**RESPONSE TO SUBMISSIONS – BUILDING R4B
SSD 8892218 MOD 1**

This response to submissions letter has been prepared following the public exhibition of a section 4.55(1A) modification application for Residential Building R4B, Barangaroo Amending DA (SSD 8892218, MOD 1). The modification application seeks approval for internal and external design changes and administrative amendments. The modification is supported by concurrent modification application's to the adjacent Residential Building R4A (SSD 6964), and also to the 'base' development consent to Building R4B (SSD 6965).

2.2.6 Updated Carpark Entrance

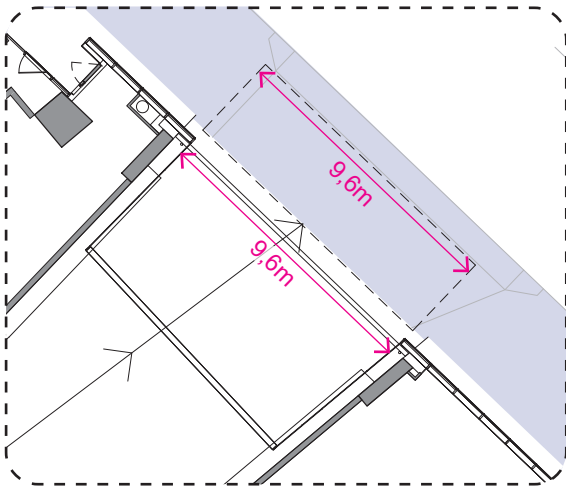
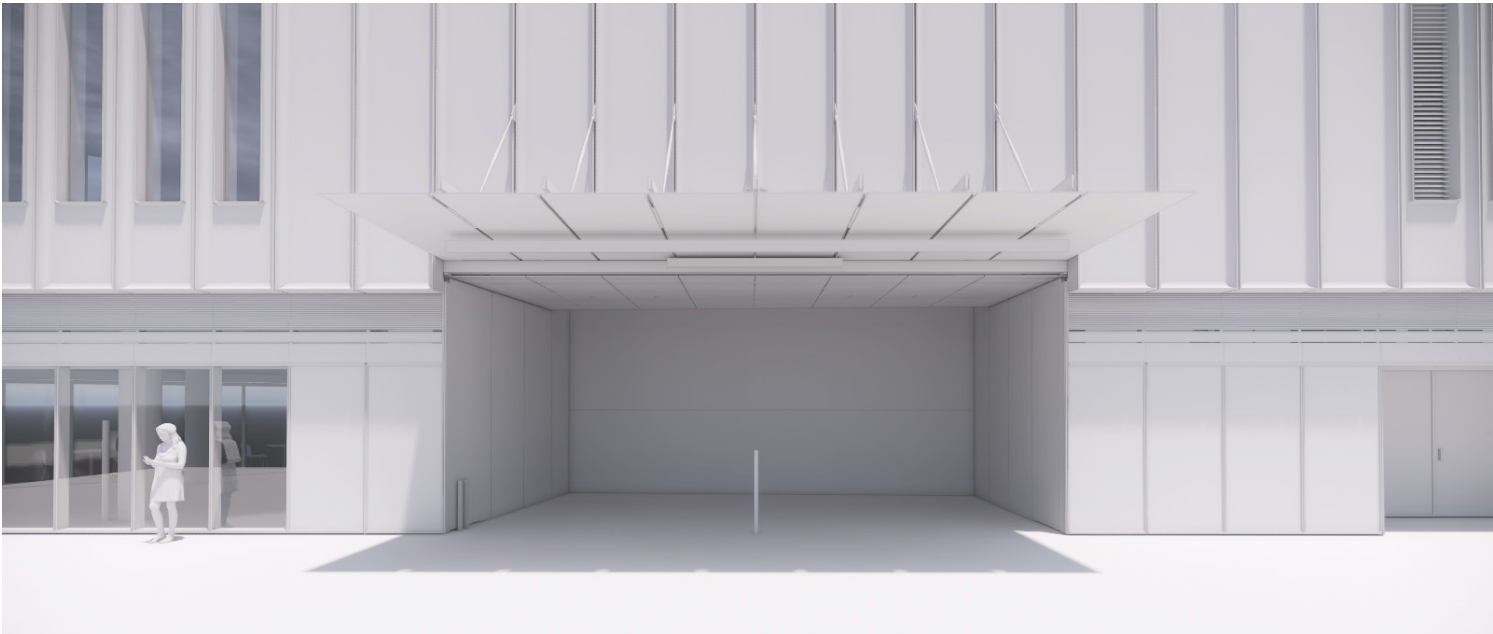
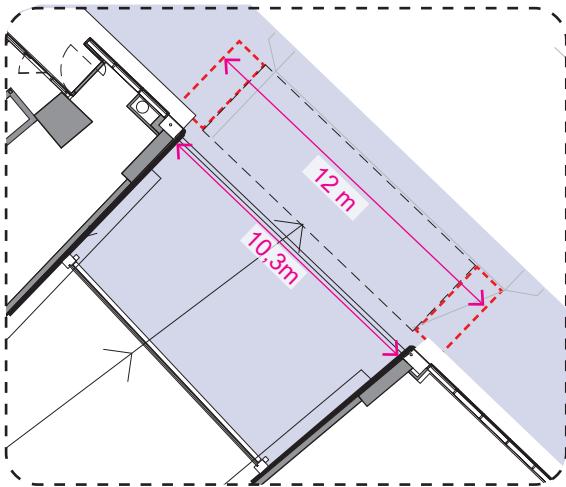
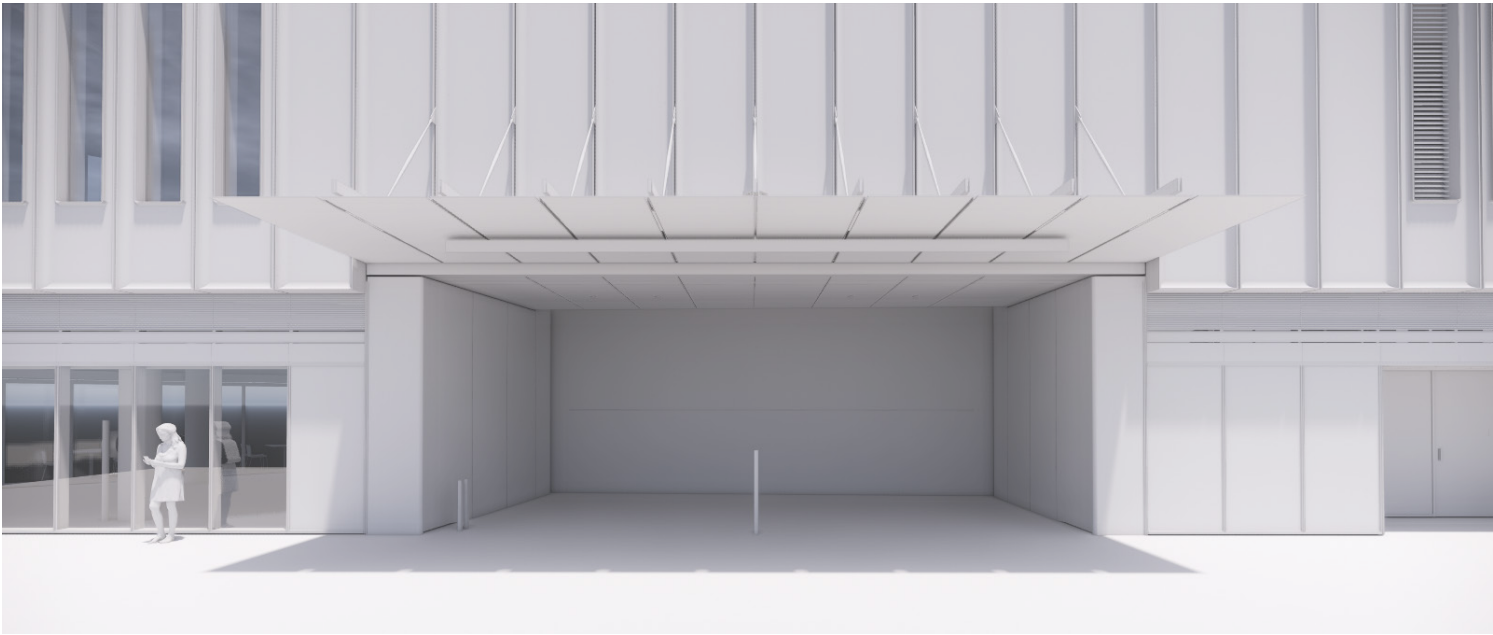
The submitted plans indicate that the ramp door is proposed to be relocated and the facade be updated, and the design report notes the carpark entry width is proposed to be increased, however, no details are provided as to the proposed new width of the opening.

The City generally recommends, as per Section 3.11.11 of the Sydney Development Control Plan 2012, that carpark openings have a maximum width of 4m to ensure pedestrian and cyclist safety and amenity is prioritised. The proposed opening of over 10m is significantly wider than this recommendation and reconsideration should be given to this aspect of the proposal.

The Building R4B basement entry driveway on Watermans Quay was previously approved to have a width of 9.6 metres. This application proposes to widen this driveway entry by 0.7 metres to 10.3 metres total within the bounds of the current building structure. This is proposed to reduce the risk of vehicle impacts with cladding on either side of the entrance ramp and potentially other vehicles approaching in the opposite direction when utilising the driveway. There is no change to the access lanes within the entry, with the amendment to enhance safety and operation .

Alongside the increase in driveway width, Council's stone paving is also proposed to be increased into the area to improve visual outcome, alongside the adjustments made to the wall cladding. The awning above the driveway has also been adjusted to reflect the increased width. The revised Design Report at **Attachment A** demonstrates the widening of the awning and driveway. A diagram indicating the increased width is shown at **Figure 1**.
